Phone: (01772) 531343
Email: peter.iles@lancashire.gov.uk
Your ref: 3/2024/0339
Our ref: 3_2024_0339-LCC
Date: 30th May 2024

**Application 3/2024/0339: Listed Building Consent for removal of existing roof trusses and replacement with new non-structural trusses.
Barn at Talbot Hotel 5 Talbot Street Chipping PR3 2QE**

Figure 12: Section

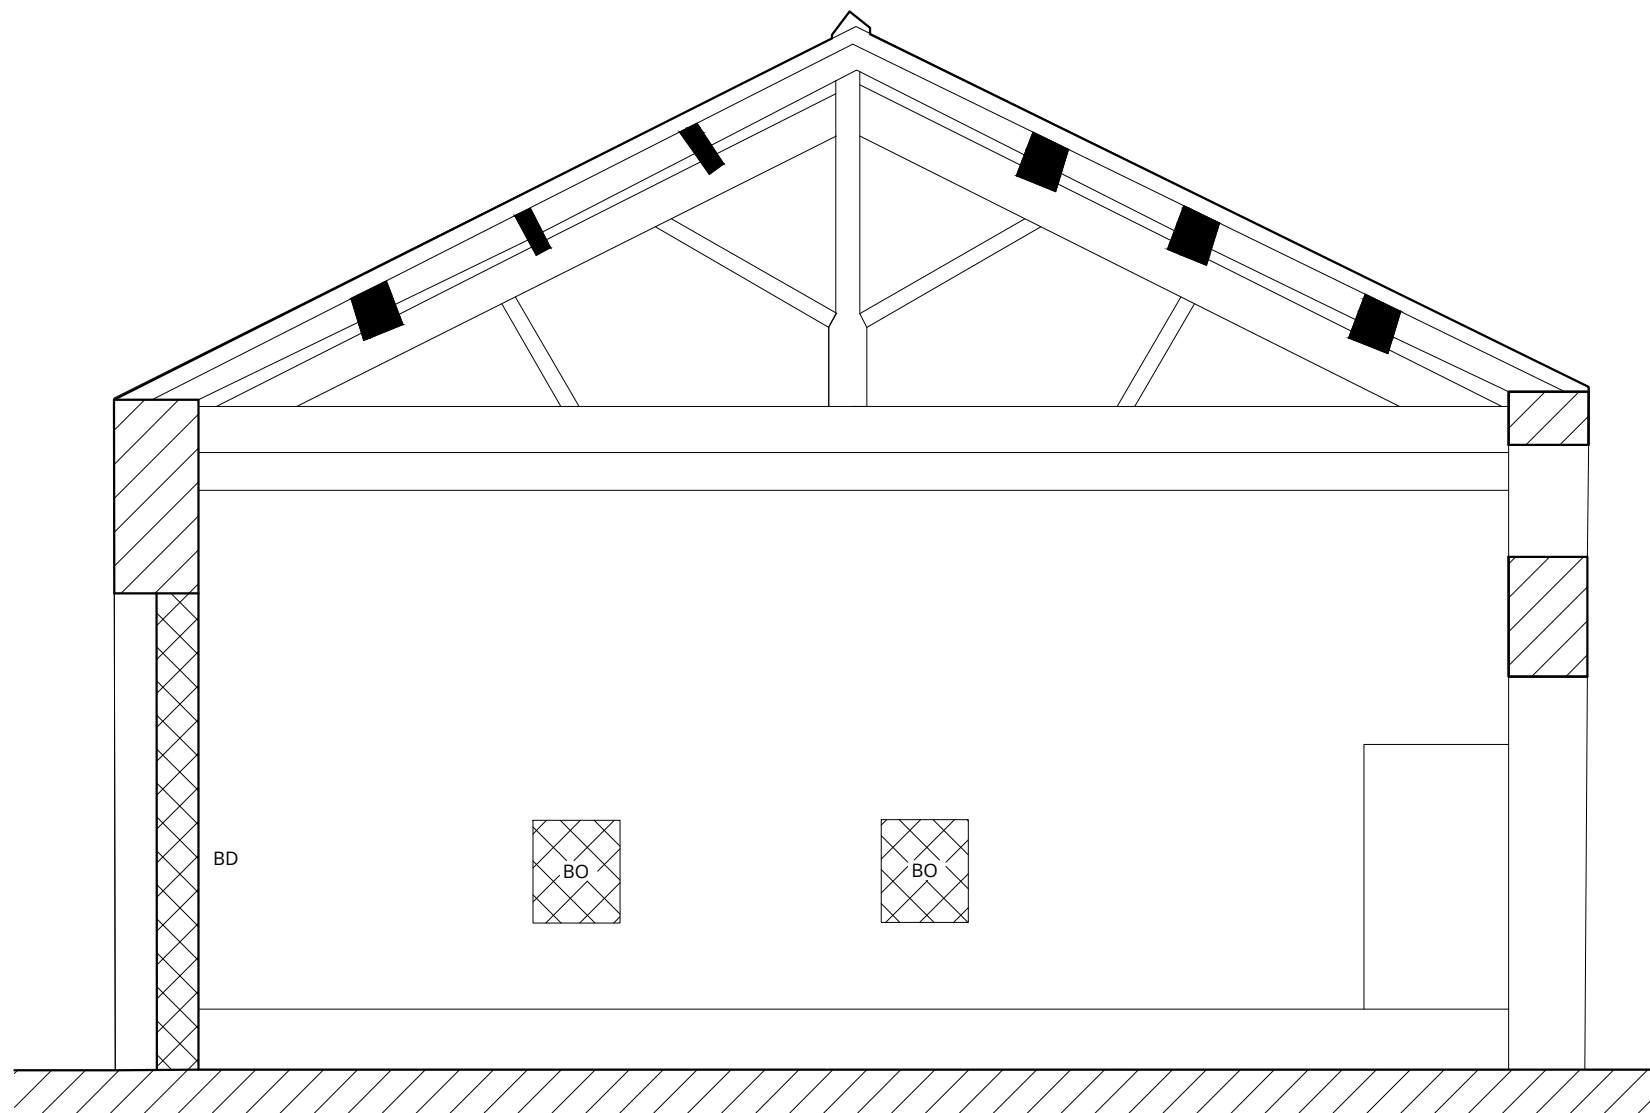
As described, the above application is for the replacement of the four existing wooden roof trusses and their replacement by a combination of steel purlins and three 'decorative false trusses'.

The historic building record for this structure (The Archaeology Co, October 2023) suggests that the original barn is of the same or similar 18th century date to the adjacent former public house but was extended at a later date. The extant roof trusses comprise (i) a pair of bolted king post trusses with diagonal bracing to the post and additional diagonal braces between the principal rafters and tie beam; and (ii) a pair of later king post trusses, lacking the diagonal bracing to the posts. The use of bolts to fasten the king posts in the earlier pair of trusses would suggest that they may not be the original roof supports but are replacements of mid or later 19th century date.

Whilst we would obviously prefer to see the original trusses repaired and retained, we would not formally object to the proposed works, if your Conservation Team are convinced that this is an appropriate way forward. No further formal recording of the building would appear to be necessary, although if, during the dismantling, historic graffiti, carpenter's, or other marks are noted. In that case we would suggest that they are carefully photographed by the applicants and copies of those photographs submitted to the Historic Environment Record to enhance the 2023 record.
